Jeanie Bourke - Re: 23 Emerson Street - BP#2015-01540

From: Jeanie Bourke
To: Tracie Reed
Date: 9/24/2015 12:14 PM
Subject: Re: 23 Emerson Street - BP#2015-01540
CC: Craig Messinger; Keith Gautreau; Peter Valcourt
Attachments: T-1 - Title Sheet.pdf

Jeanie, Attached please find revised sheets for the 23 Emerson Street project addressing your review notes.

S-1.1

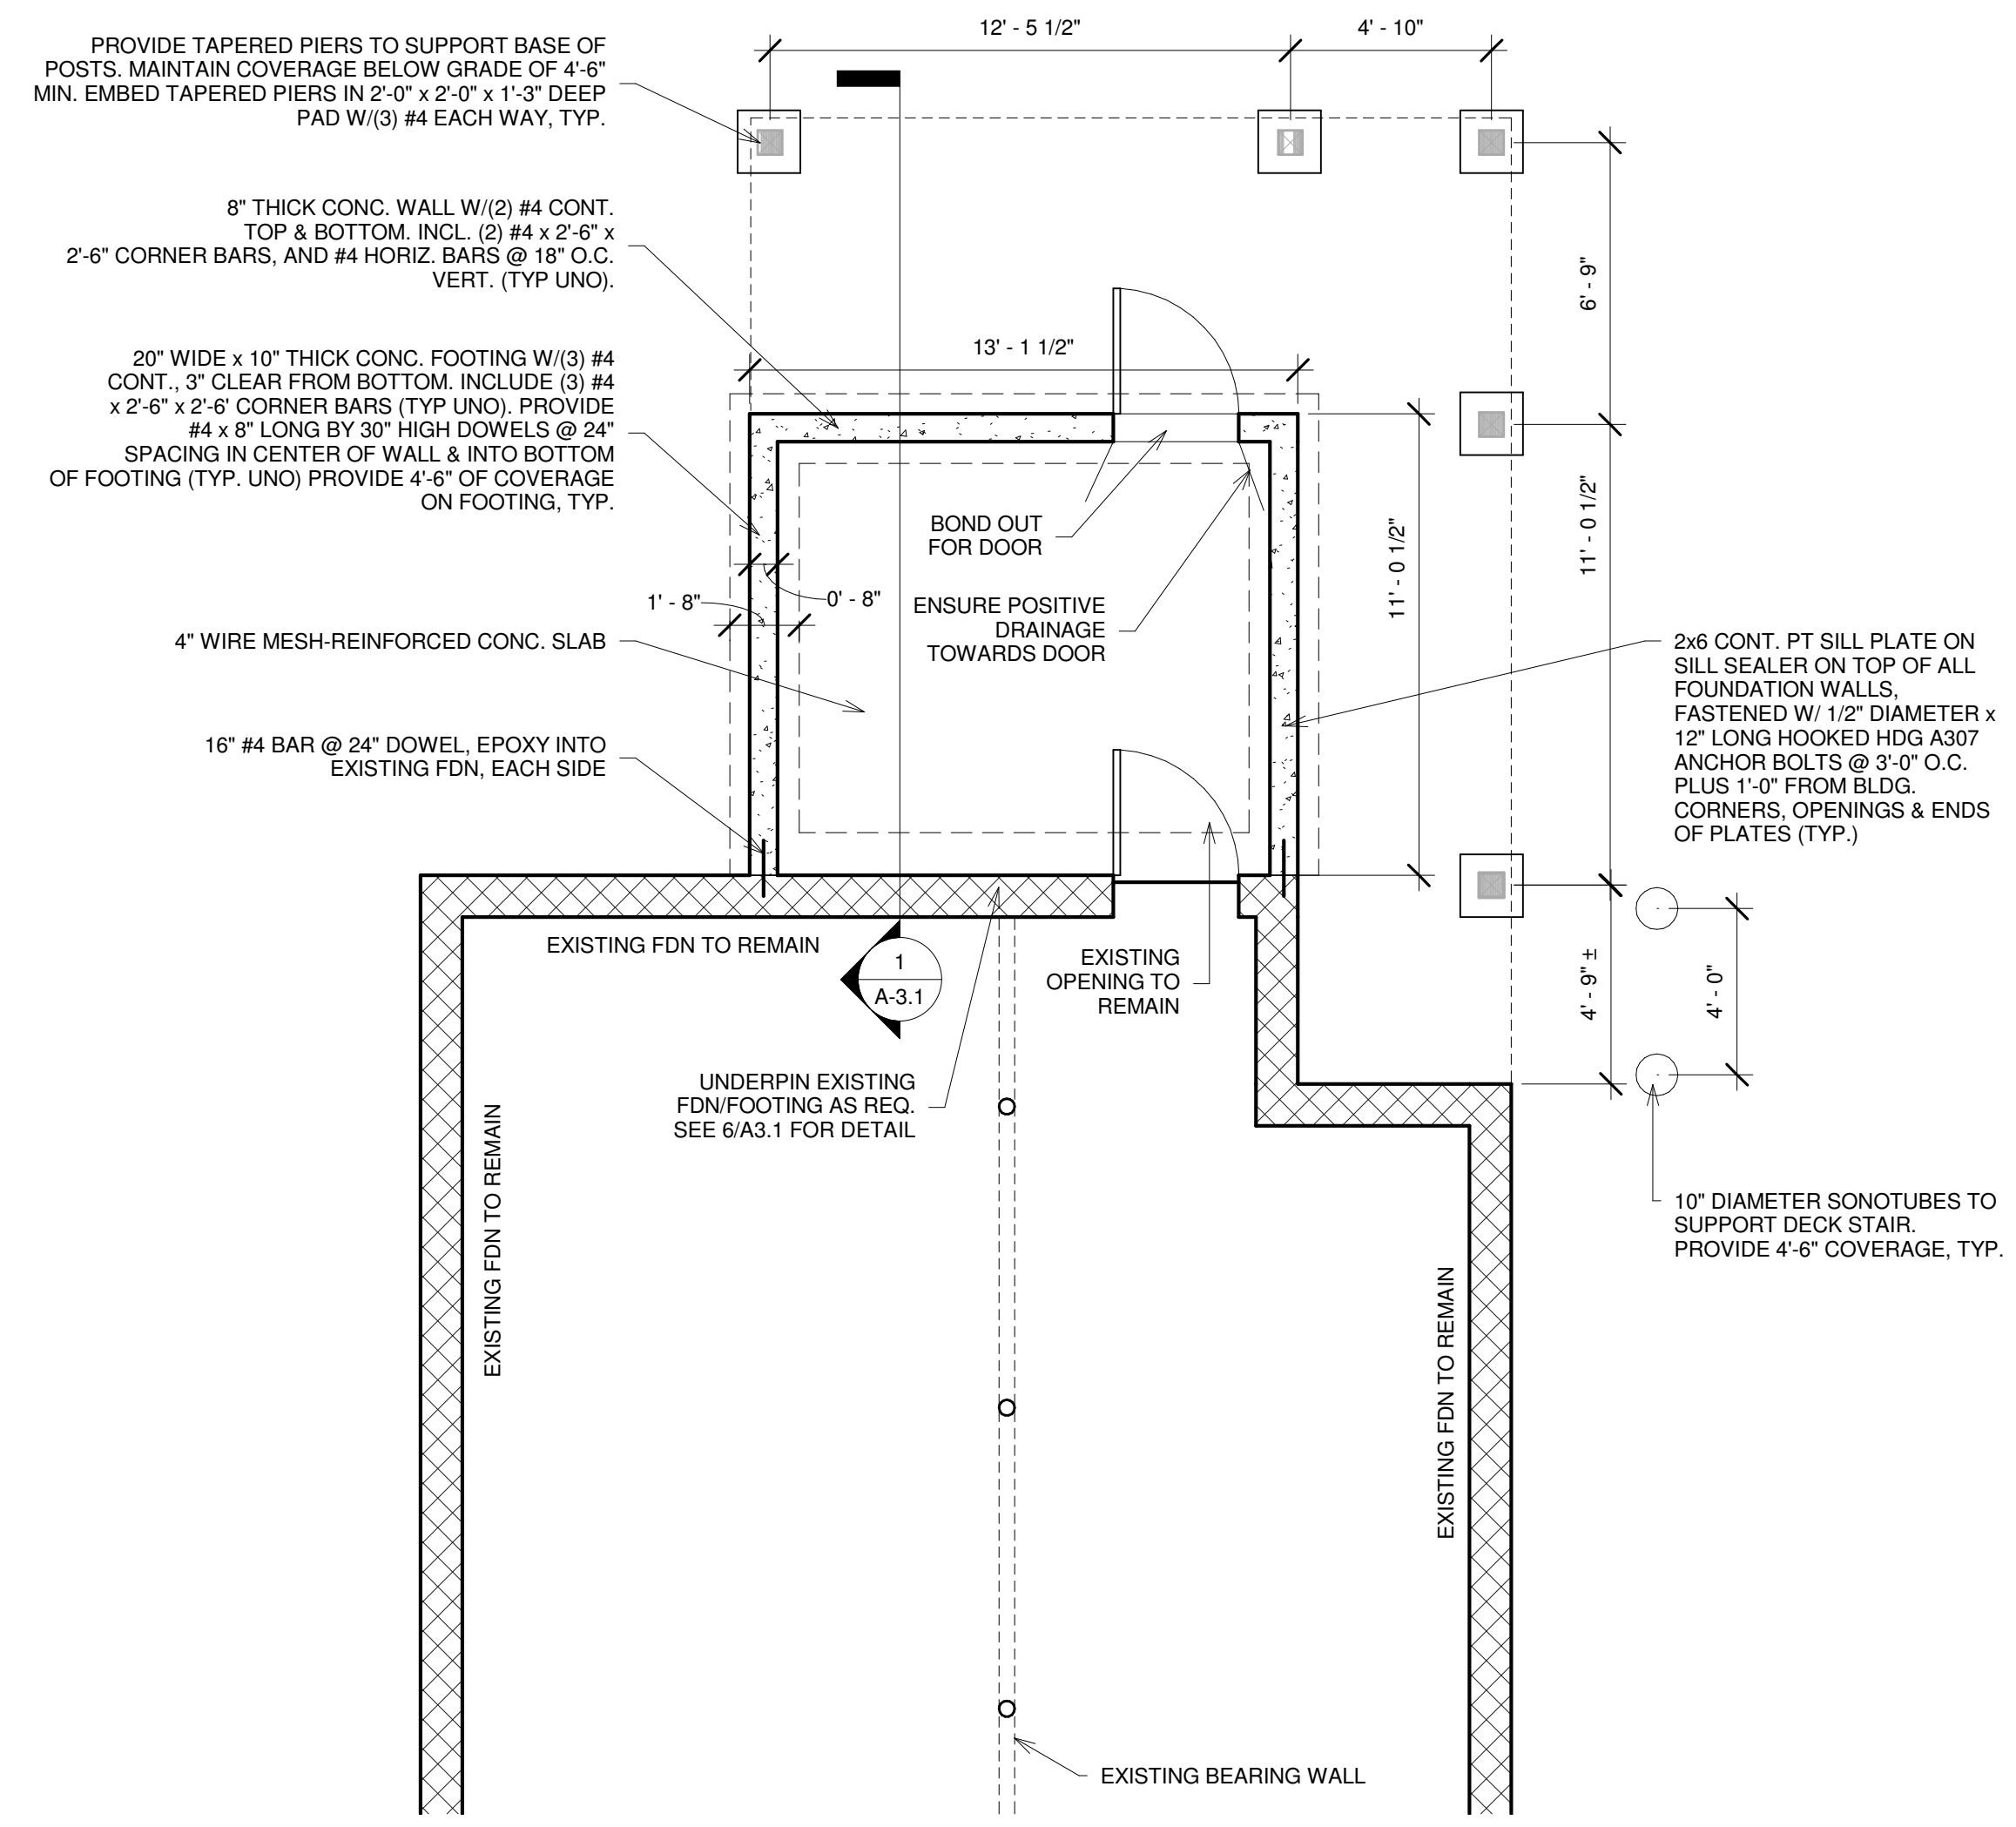
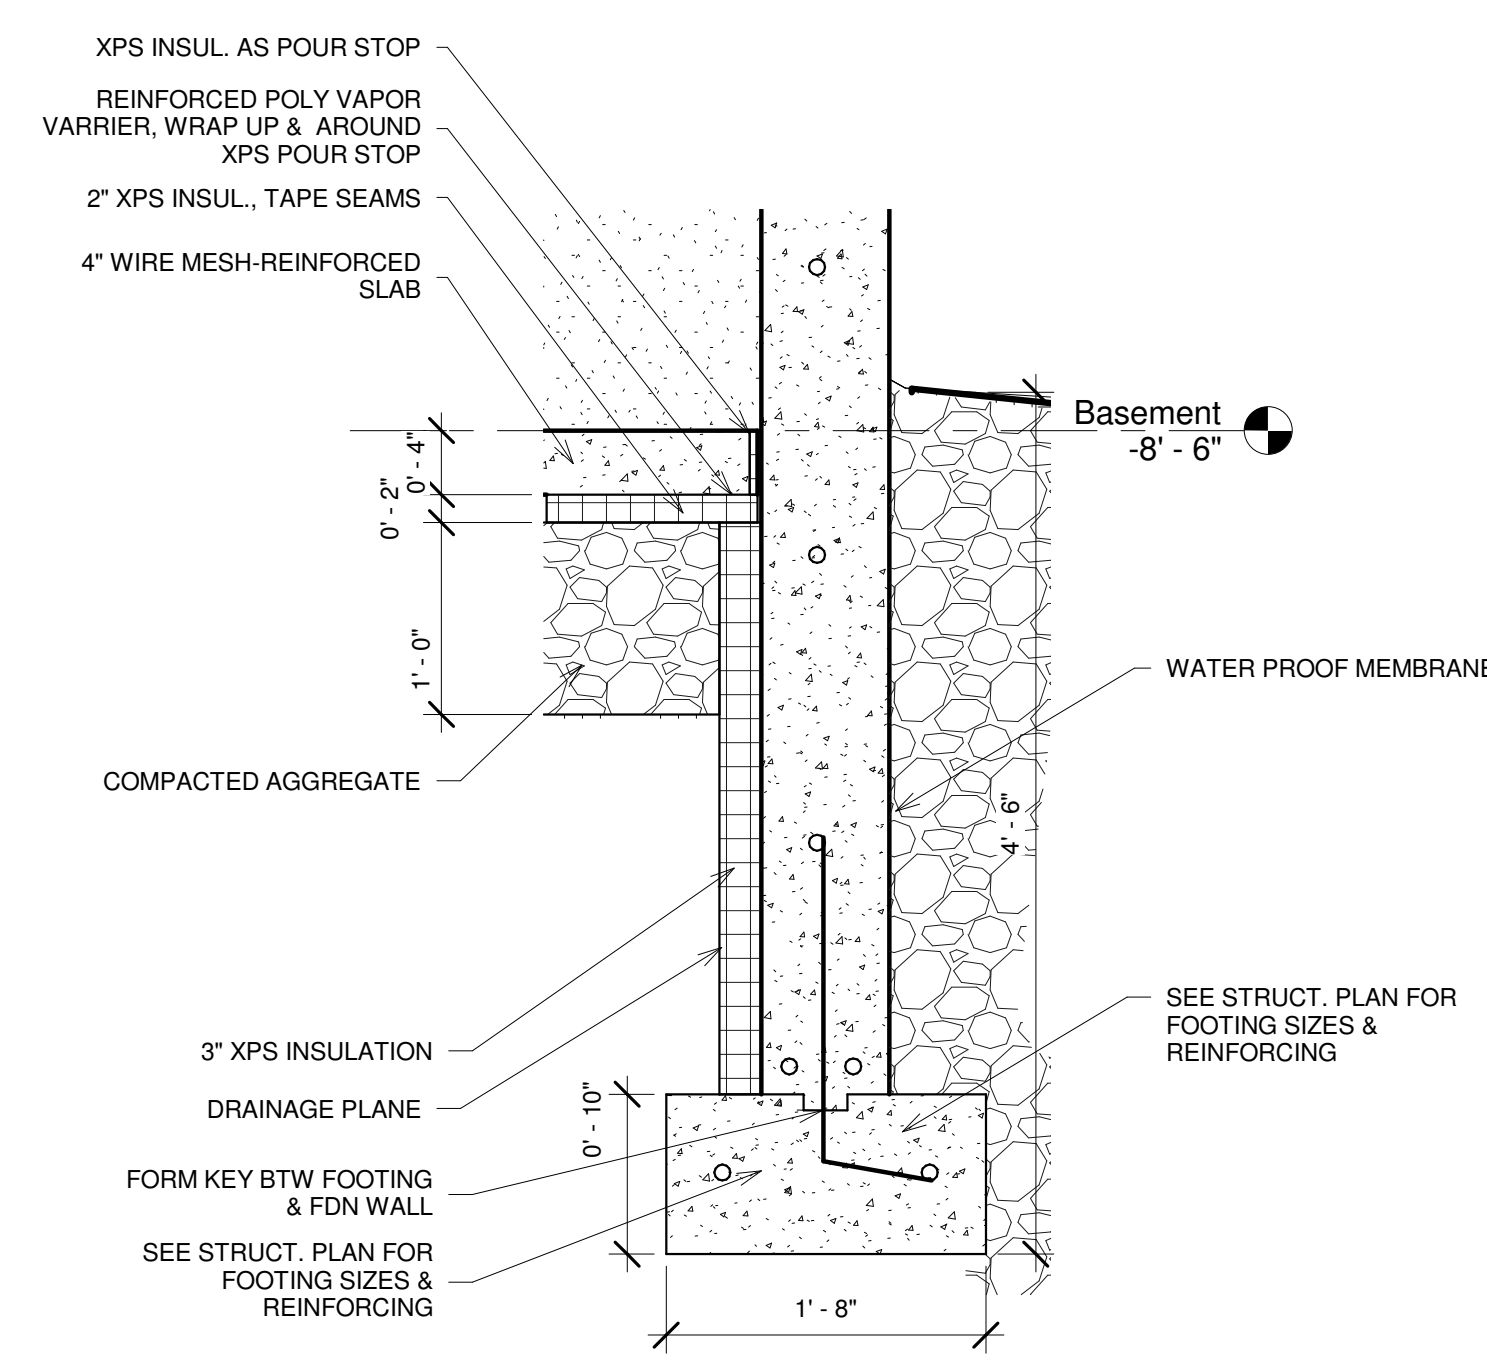
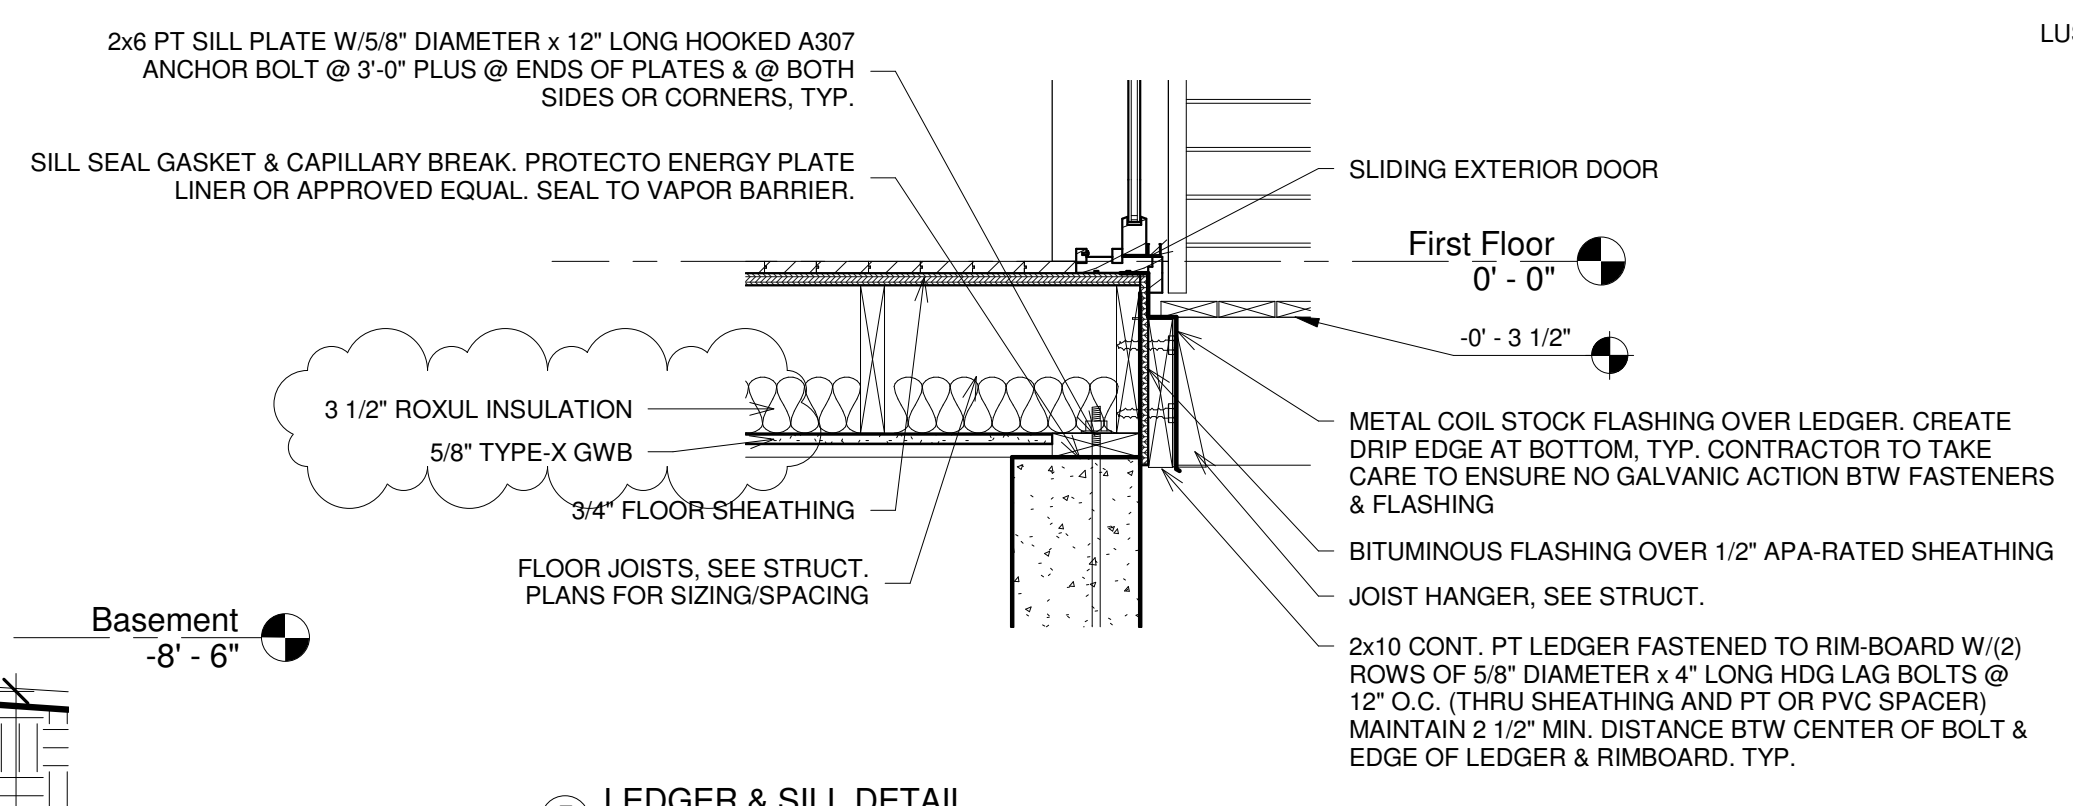
Basement Use/Separation | The basement is unoccupied space with no storage. The space will be separated from the first floor unit with a 1-hour rated assembly, with a STC-rating of 58, meeting UL L569 and insulated with 3 ½" Roxul Safe and Sound insulation. See detail 5/S-1.1.
